2025 Financial Assurance Estimate Form (with pre-plat construction)

PROJECT		PCD File No.	
Project Name: Kristin Estates		SF2521

PROJECT INFORMATION			
Project Name: Kristin Estates	Date: 5/14/2025	PCD File No.

PROPOSED PRIVATE ROAD IMPROVEMENTS - PLAN VIEW

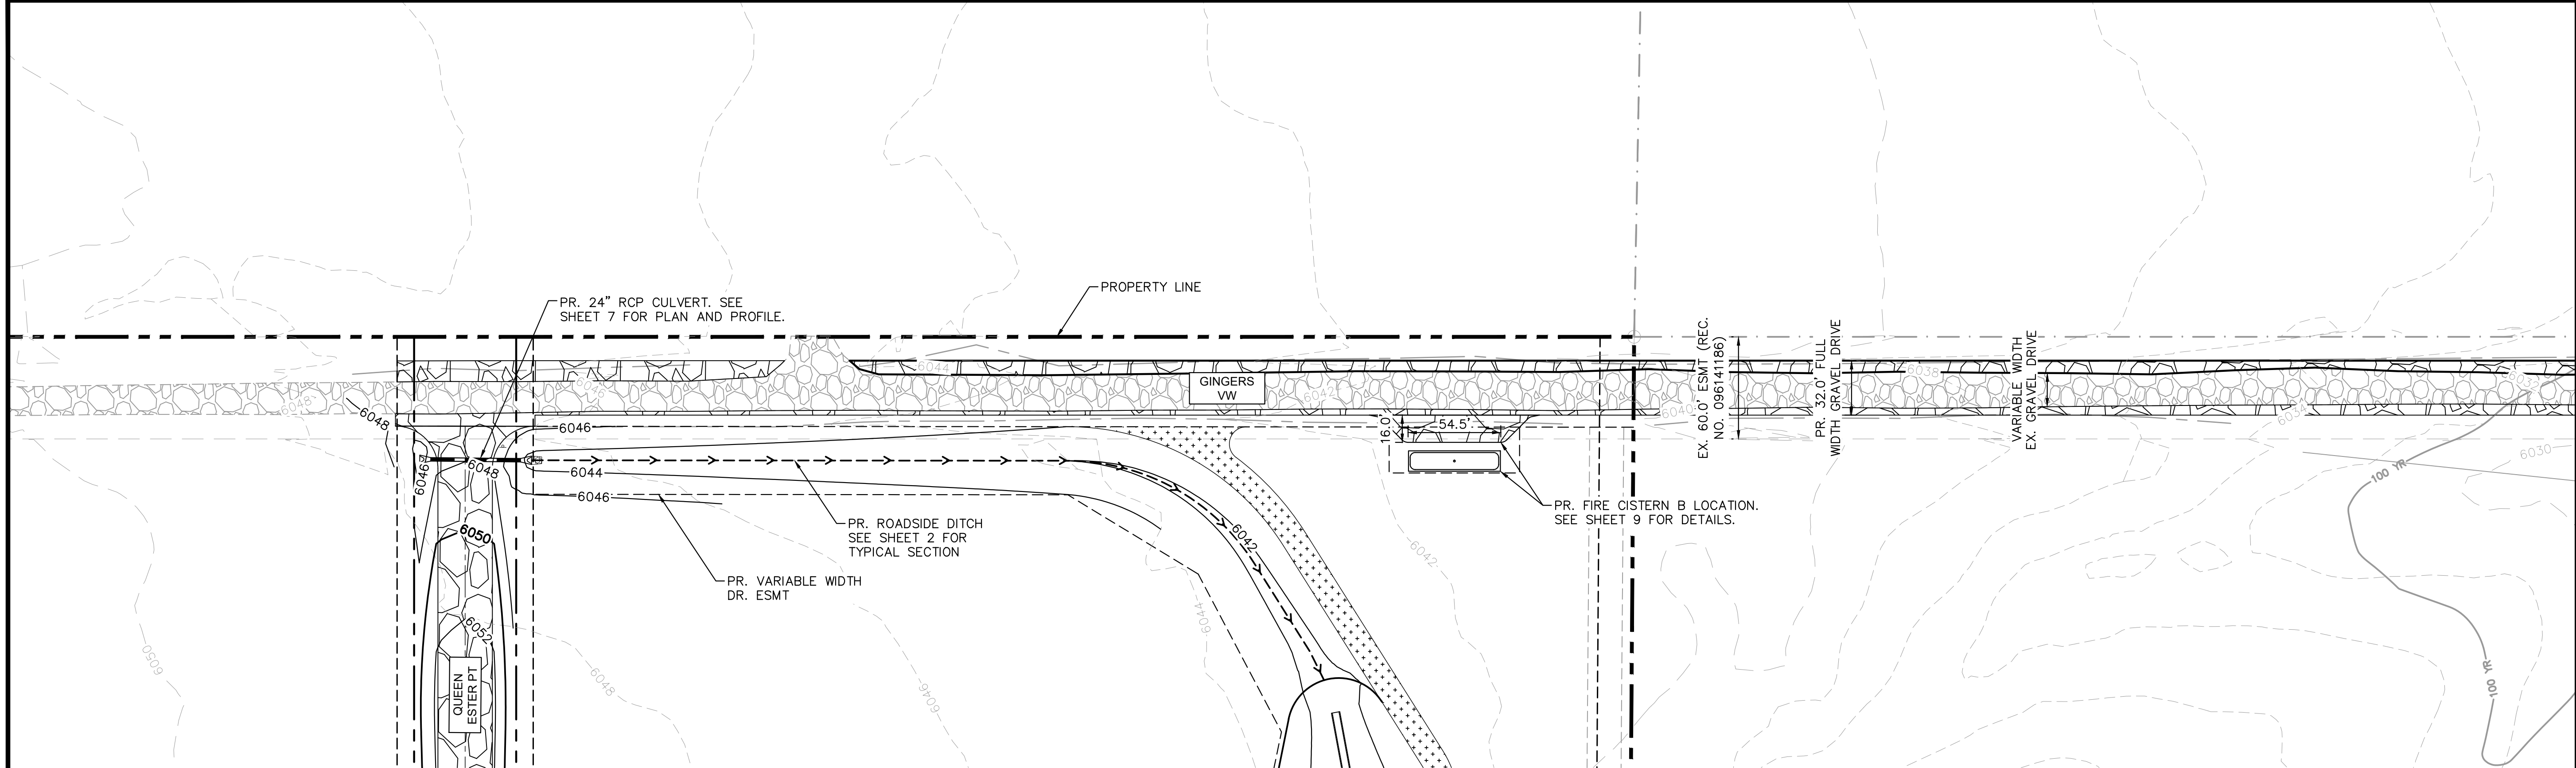
Update road material and quantities as needed per comments in CDs.

Street signs needed for internal roadway and verify if signs needed for intersection of north/south road with Hwy 94.

KRISTIN ESTATES FINAL PLAT  
EL PASO COUNTY, COLORADO  
GRADING AND EROSION CONTROL PLANS  
GEC PLAN - INTERIM

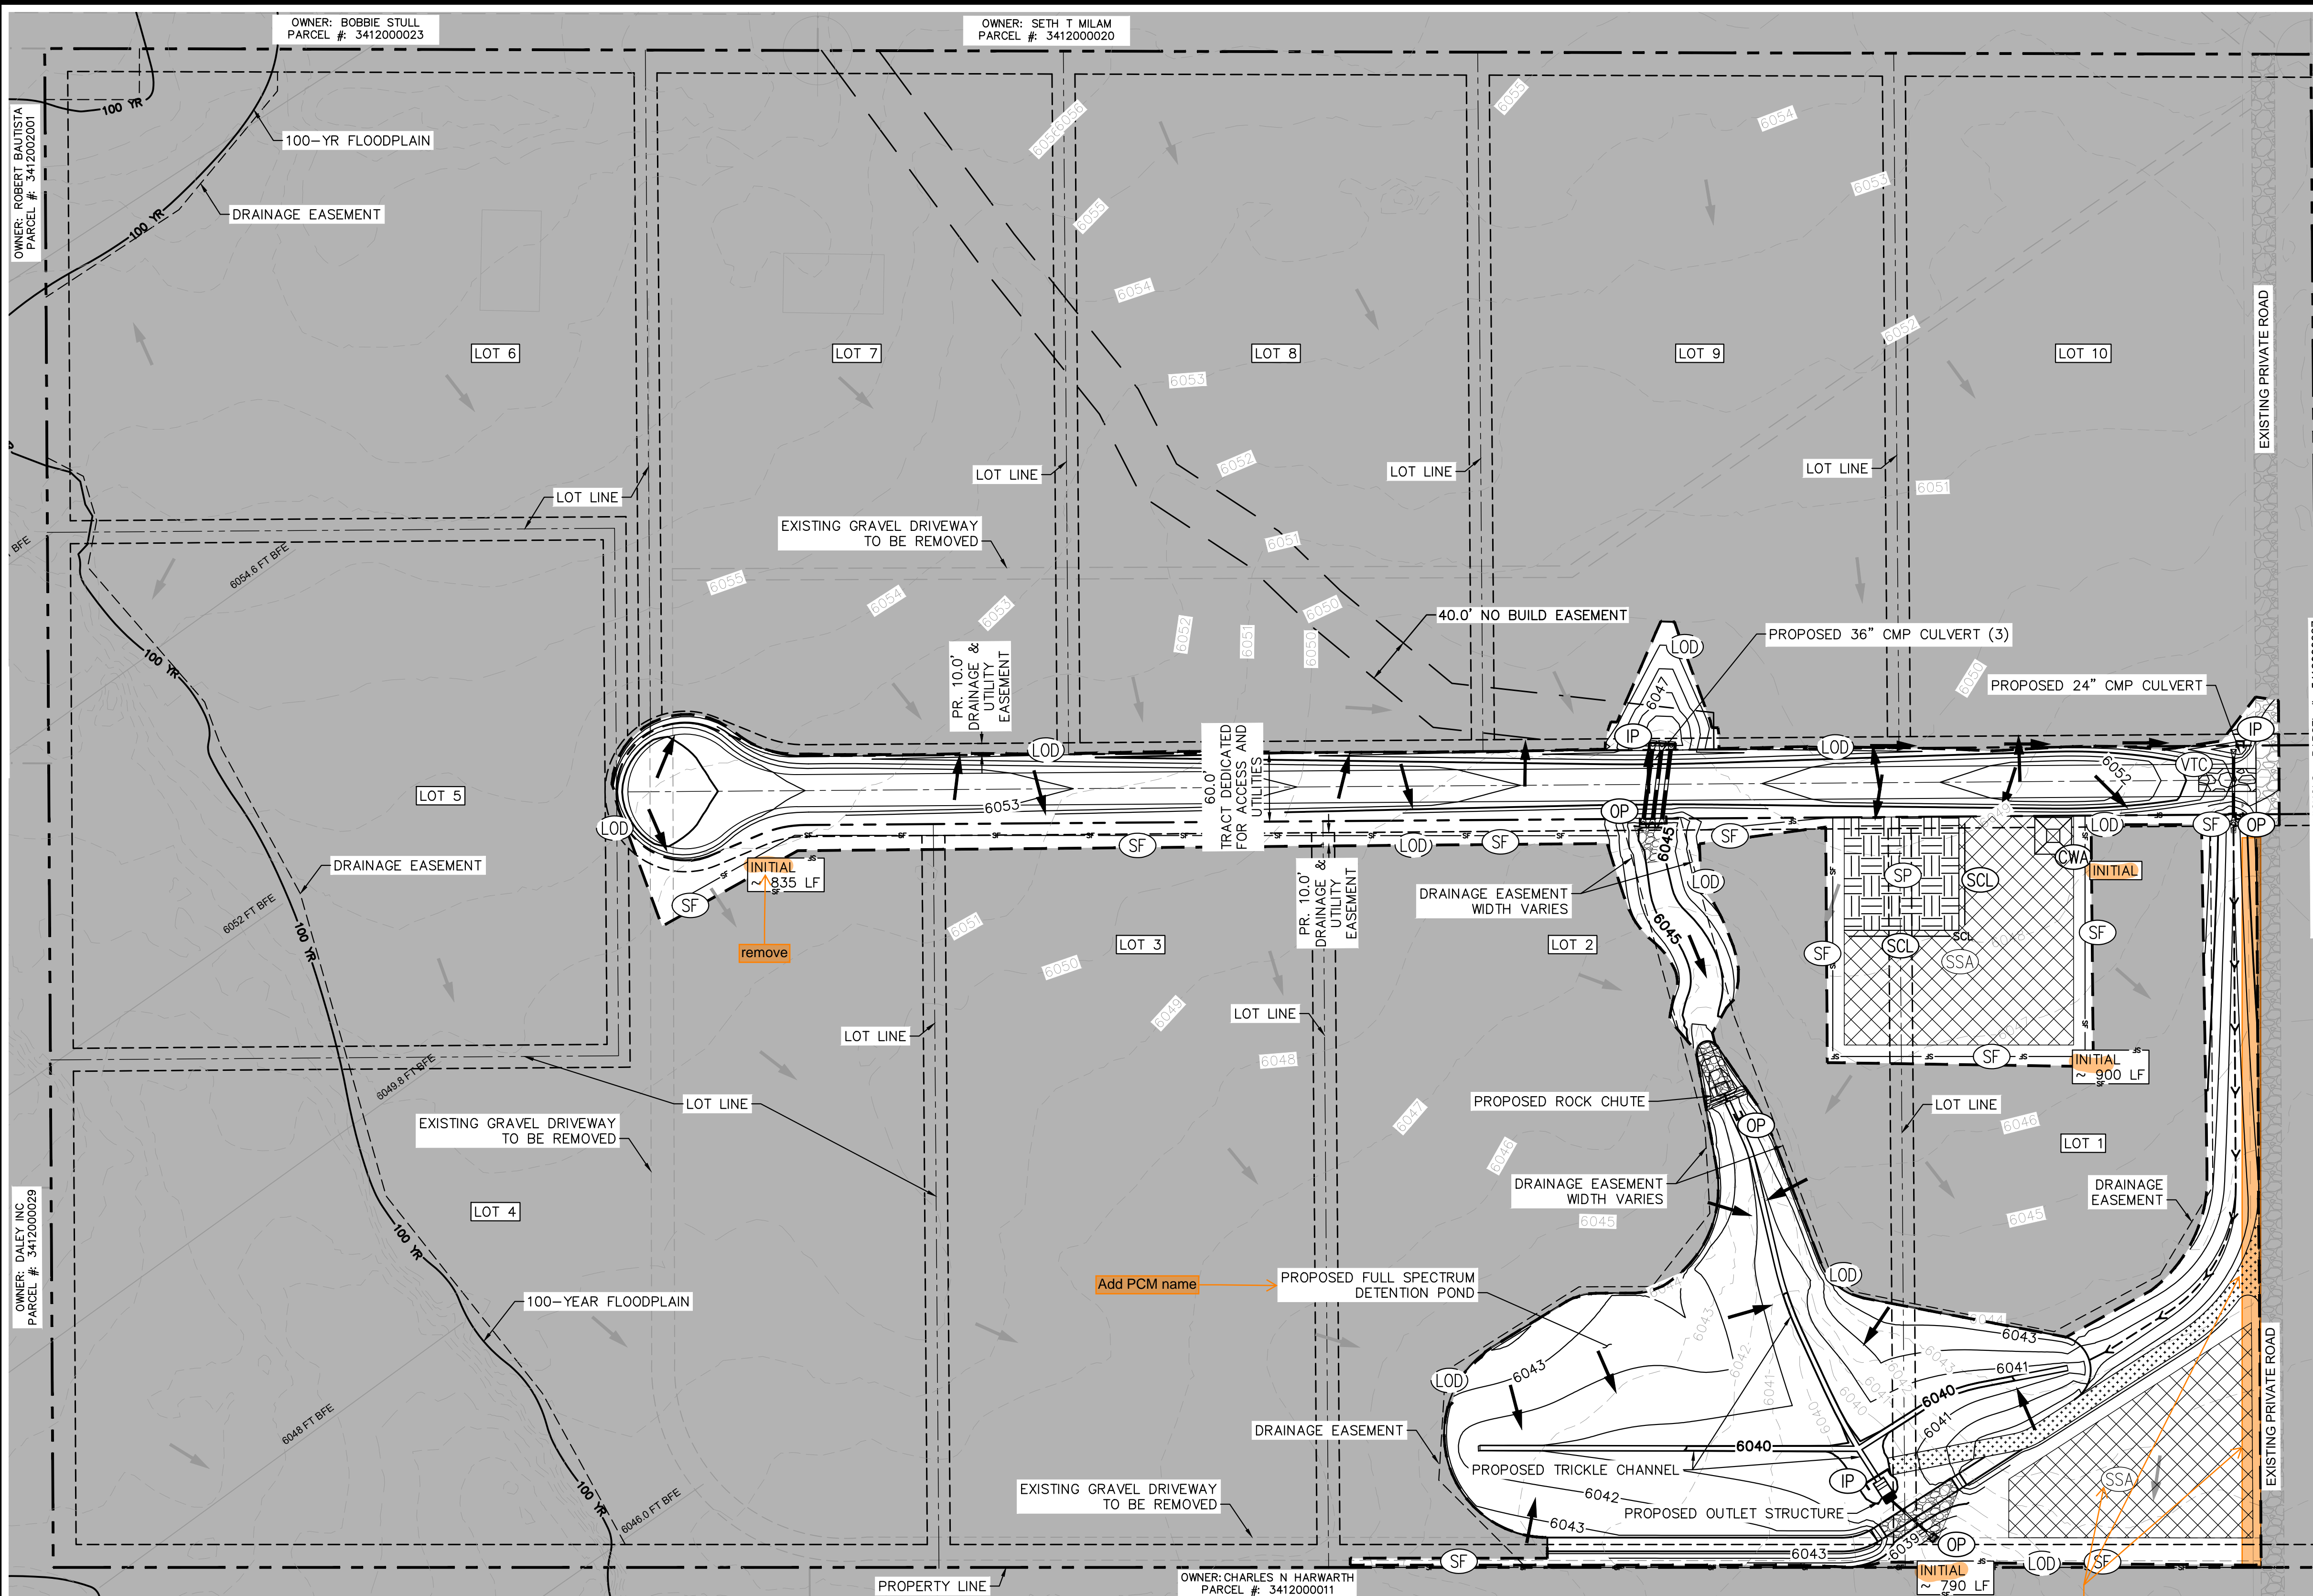
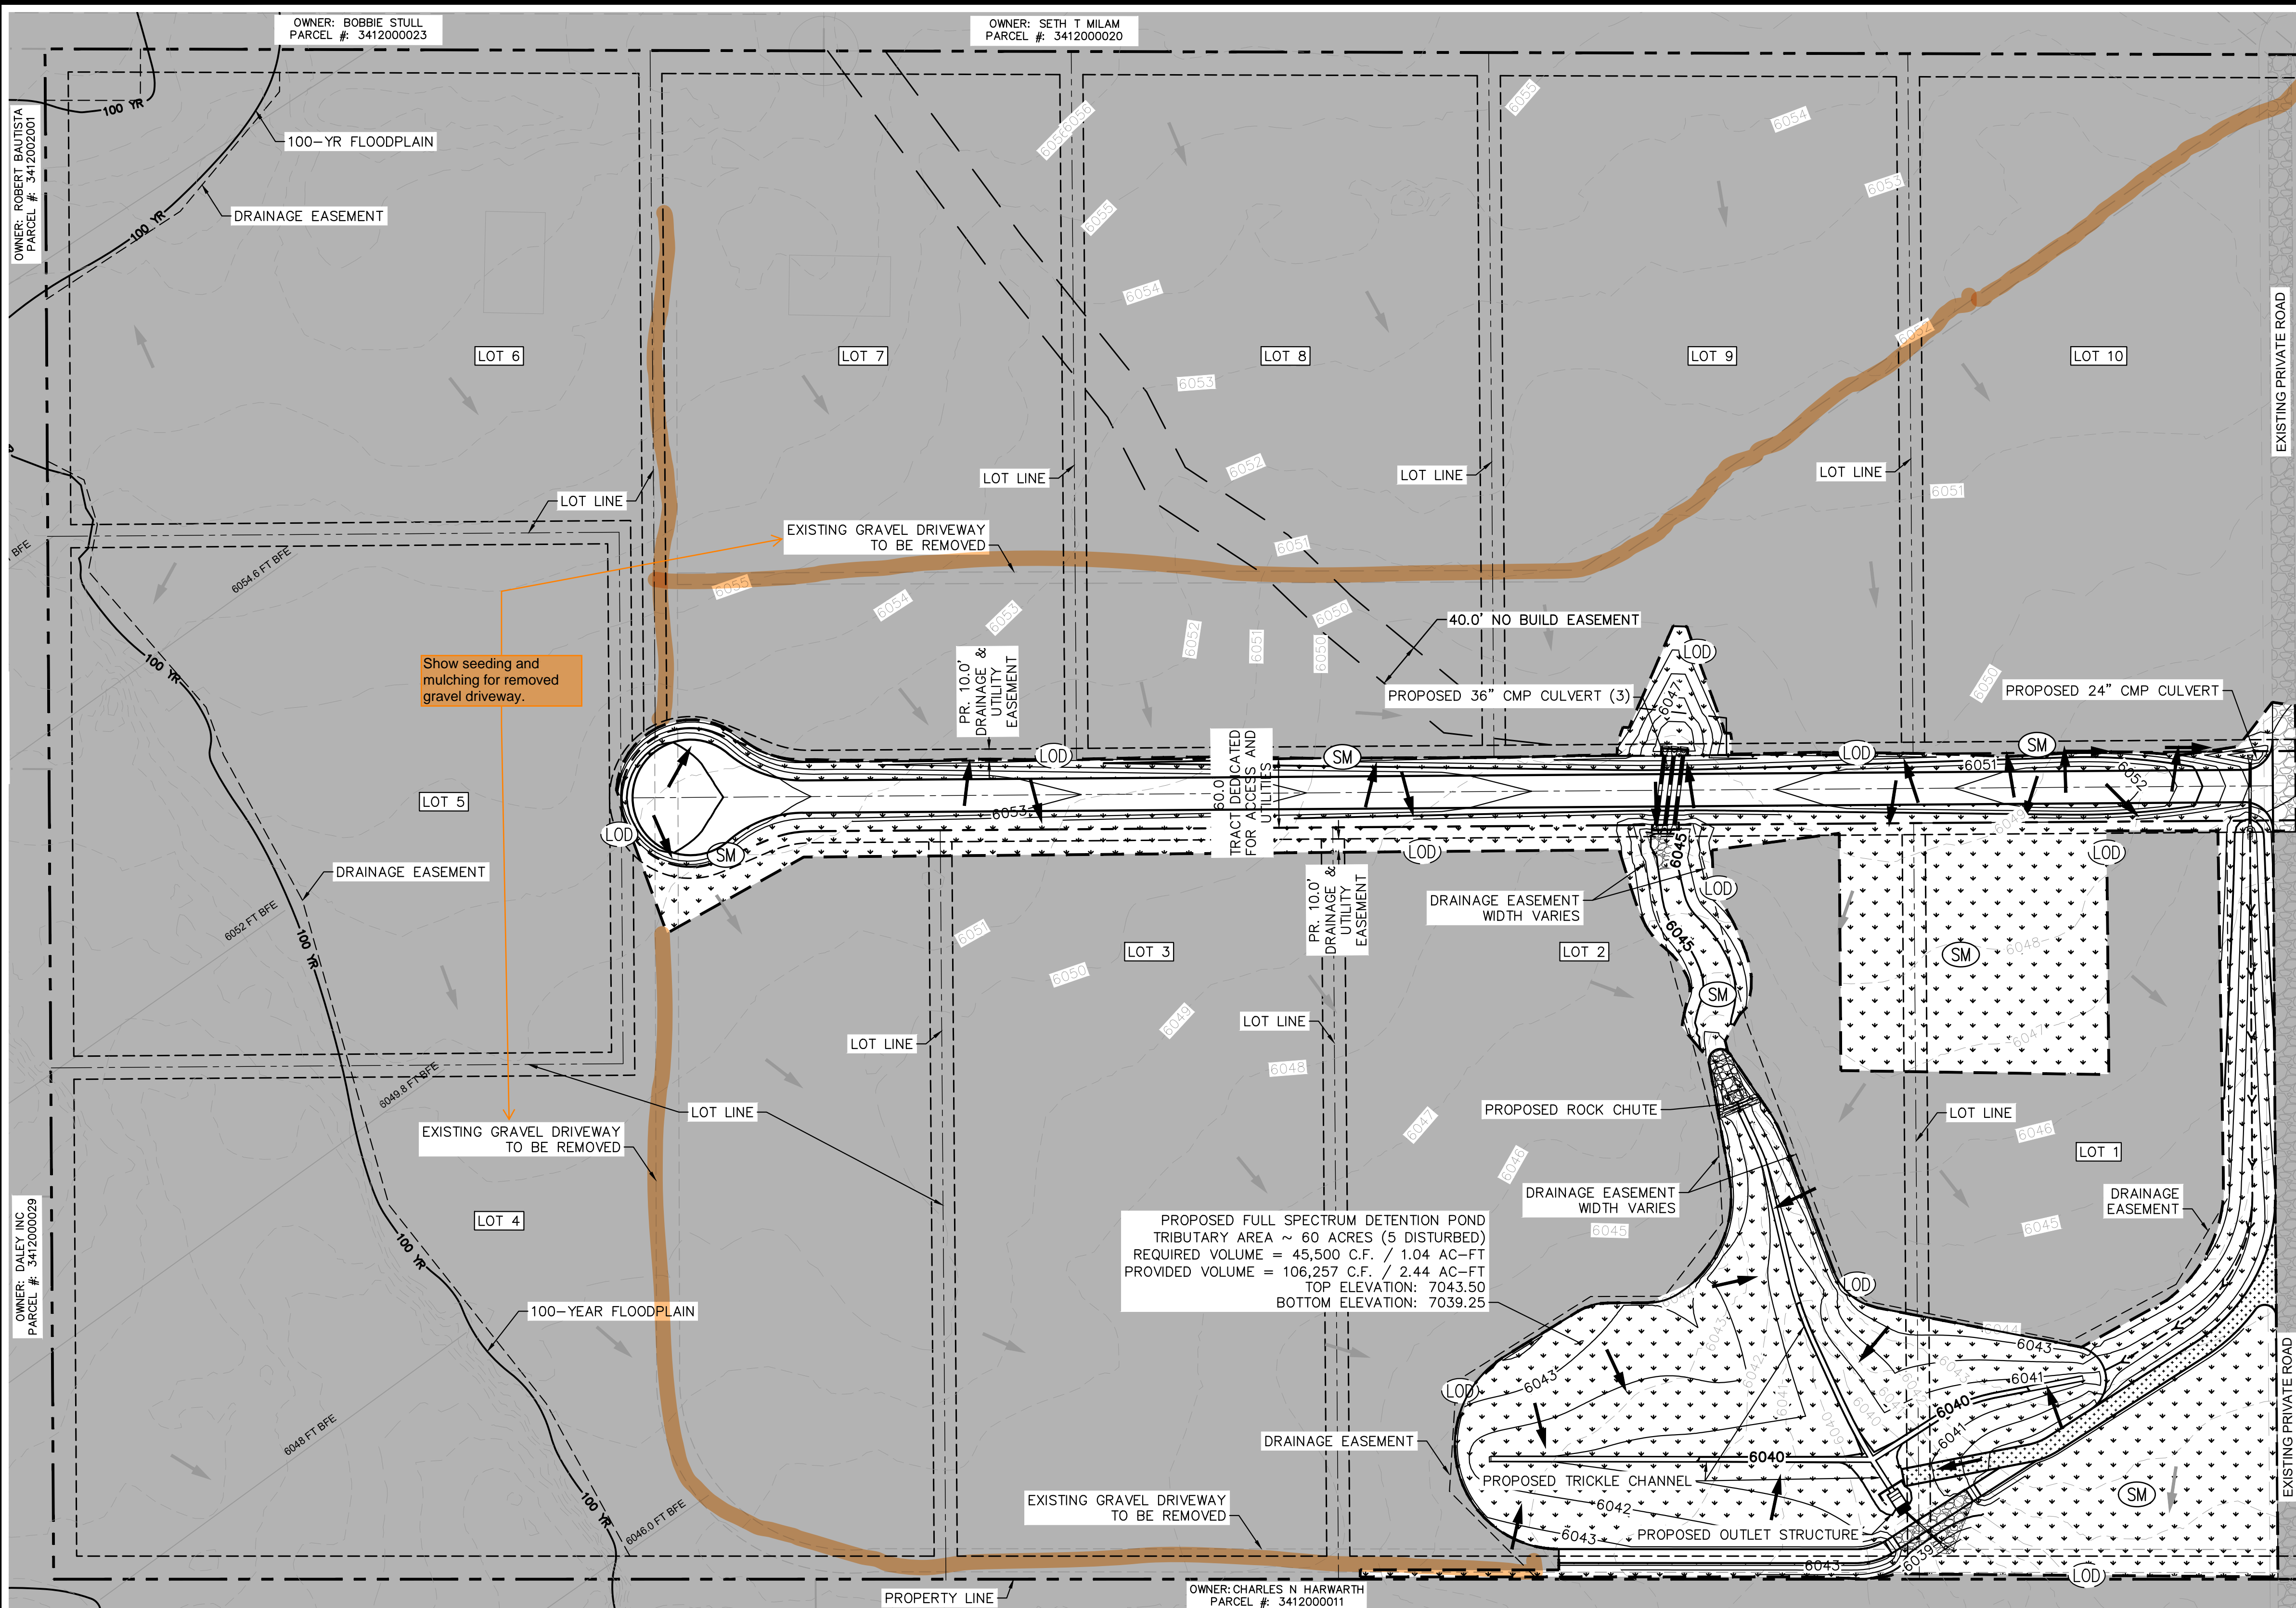
~900 LF in GEC
